City of Albuquerque Stormwater Construction Site Inspection Report

ESC File No.	K09E048B	Project Name:	Dutch Brothers		
NPDES Id. No.	NMR1005FQ	Location:	210 98th St NW		
9/14/2023	Owner		Contractor		
Operator	Heritage Trails Development, LLC				
Contact name & title	John Caglia		Joseph Green		
e-mail	john.caglia@dutchbros.com		jgcsdevelopment@gmail.com		
Contact Phone #	714-883-9092		469-888-3285		
COA Inspector	Chancellor English		Start/End Time:	1030am	
Construction Phase:	infrastructure nearly complete				
Type of Inspection:	<input type="checkbox"/> Regular	<input type="checkbox"/> Storm Event	<input type="checkbox"/> Post Storm Event >0.25"	<input type="checkbox"/> 311/Complaint	<input checked="" type="checkbox"/> Follow Up
Weather at time of inspection?	Clear		Temperature: ~	80	
Estimated date of last storm 0.25" or greater	9/13/2023

Job Number: 22187
Sheet: C13
2019 DB
Franchising USA, LLC

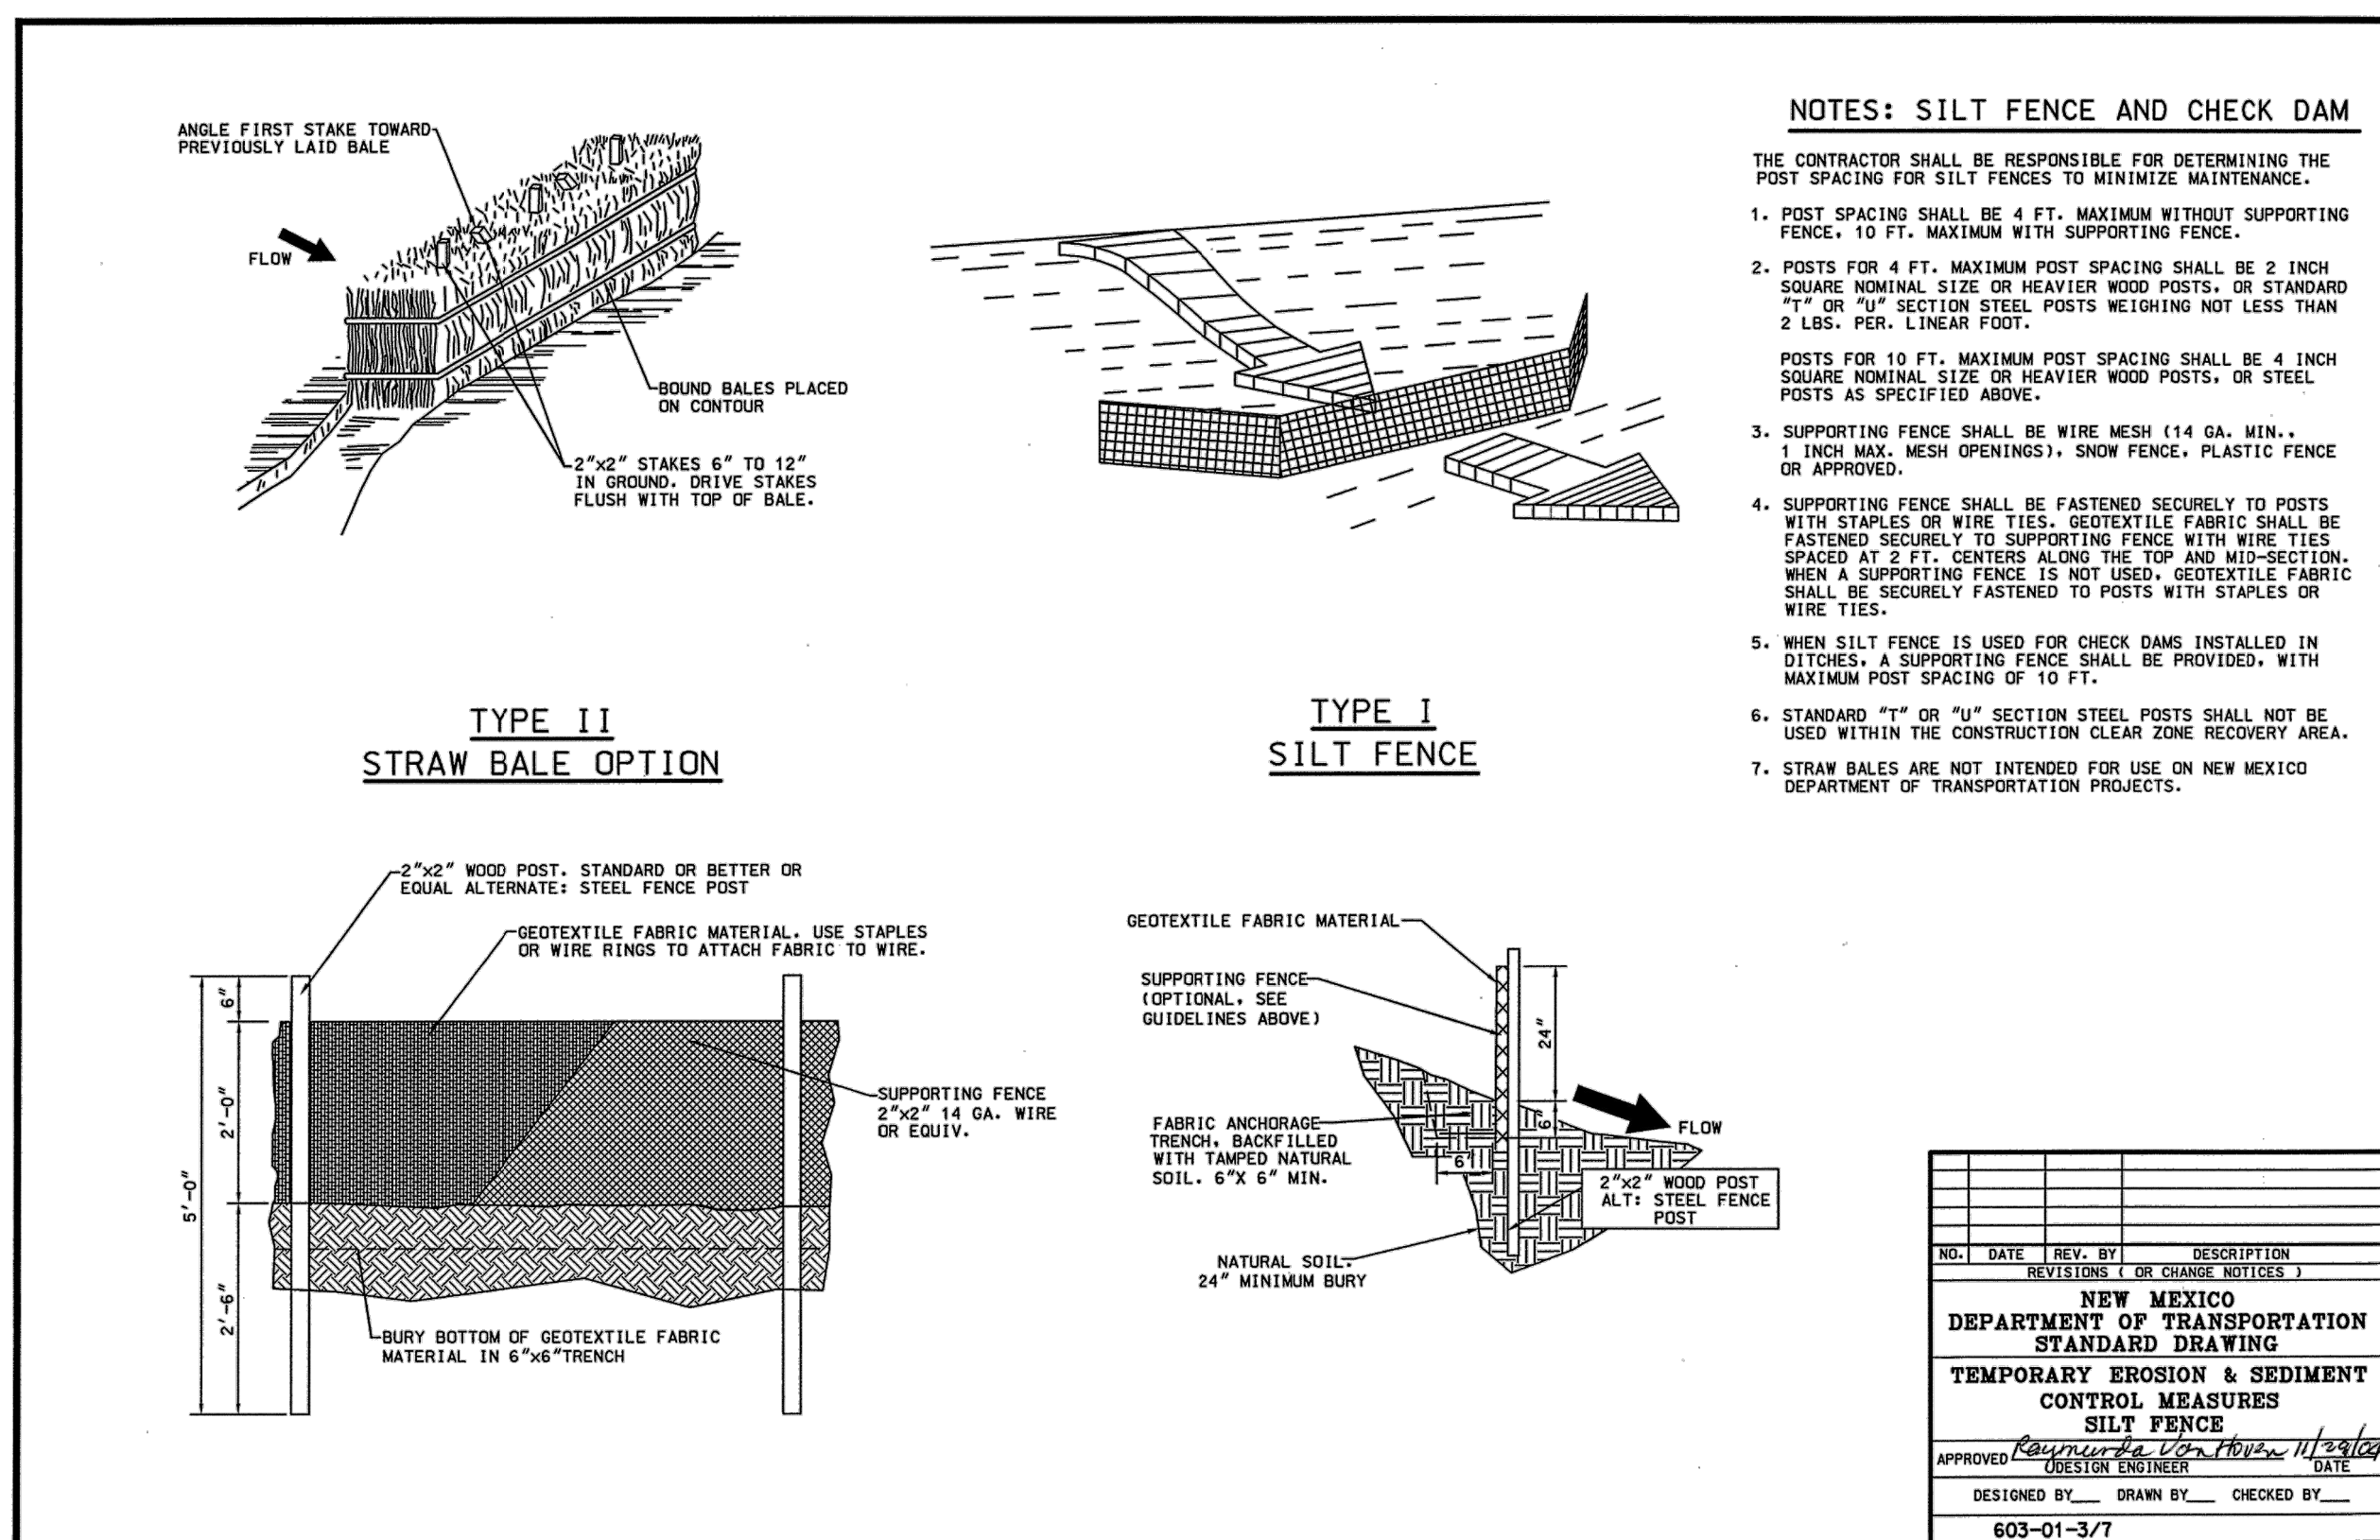
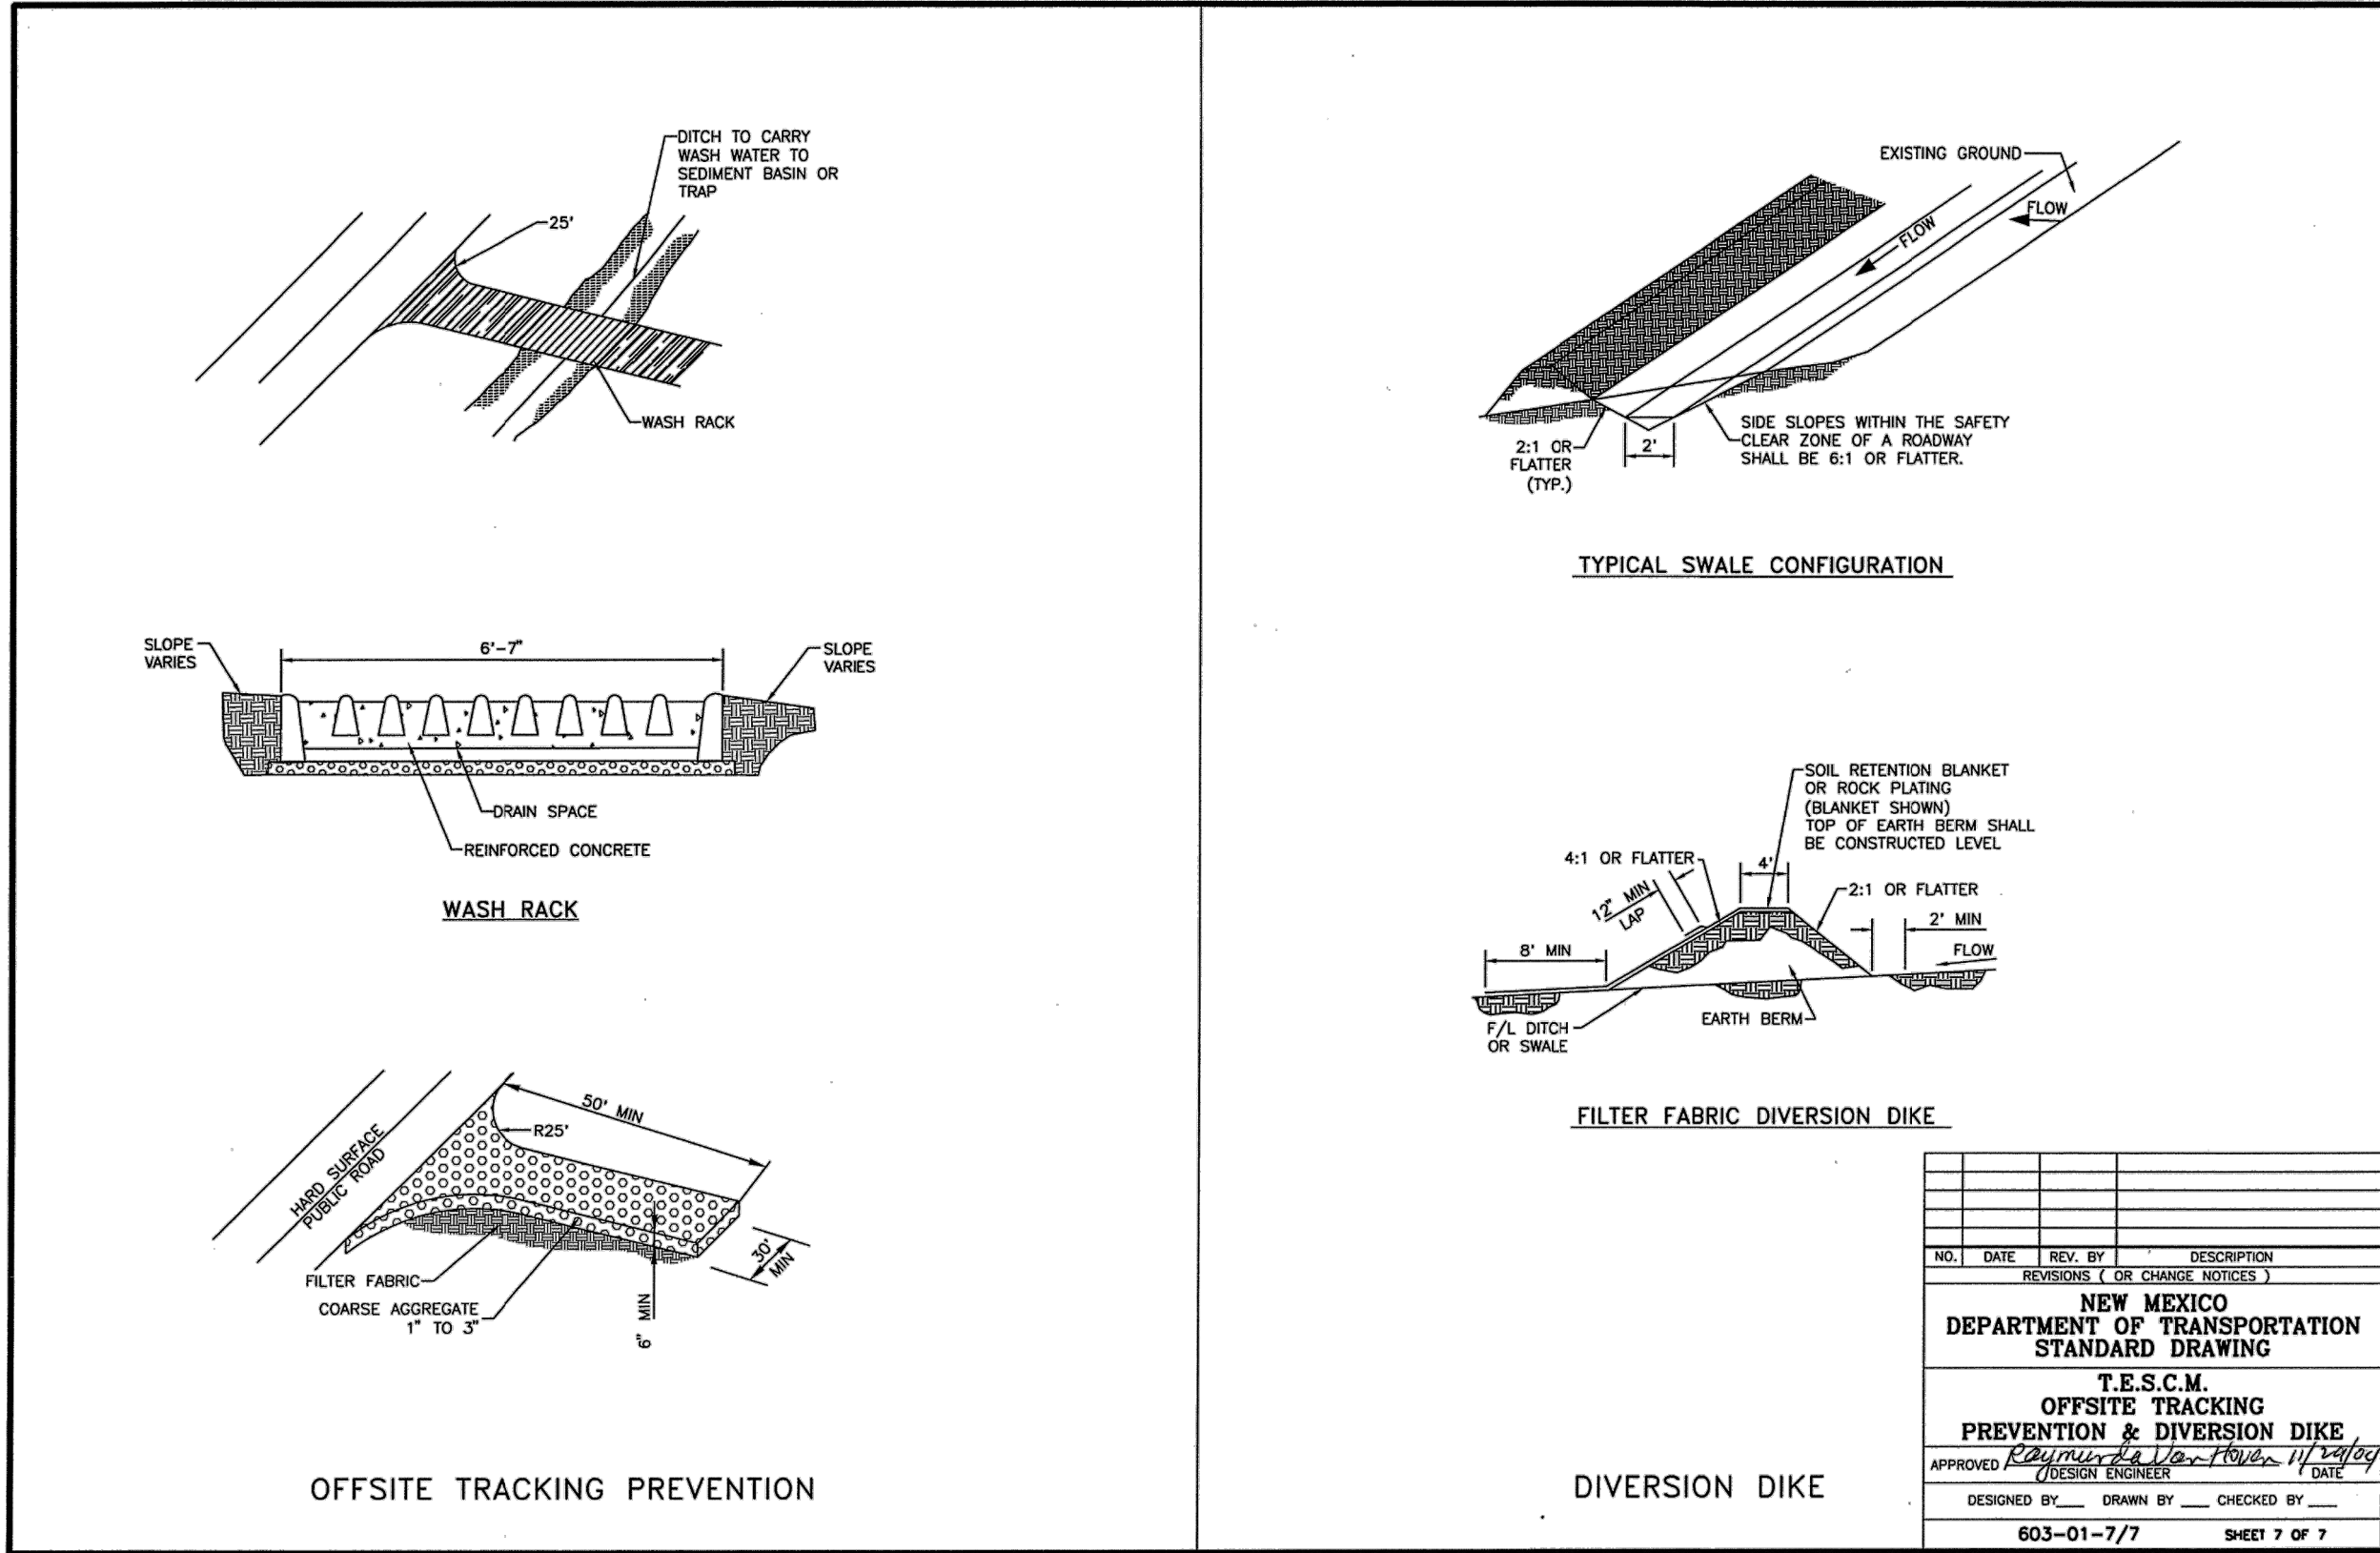
3	There are multiple gaps in the perimeter silt fence in violation of CGP Parts 2.1.2 and 2.1.4. Subcontractors are not using the designated construction exit and instead using a low point of the site for access in violation of CGP Part 2.2.4. Required mitigation: CGP Part 2.1.2 requires you to design and install all stormwater controls in accordance with good engineering practices, including all design specifications. You must install sediment controls along any perimeter areas of the site that are downslope from any exposed soil or other disturbed areas per CGP Part 2.2.3. To minimize track-out, you must restrict vehicle use to properly designated exit points and use appropriate stabilization techniques at all points that exit onto paved roads, according to CGP Part 2.2.4.				
4	There were spots of concrete washout on the ground and the site is missing a designated washout container in violation of CGP Part 2.3.4. Required mitigation: CGP Part 2.3.4 requires you to direct wash water into a leak-proof container or leak-proof and lined pit and to not allow liquid wastes to be disposed of through infiltration or to otherwise be disposed of on the ground.
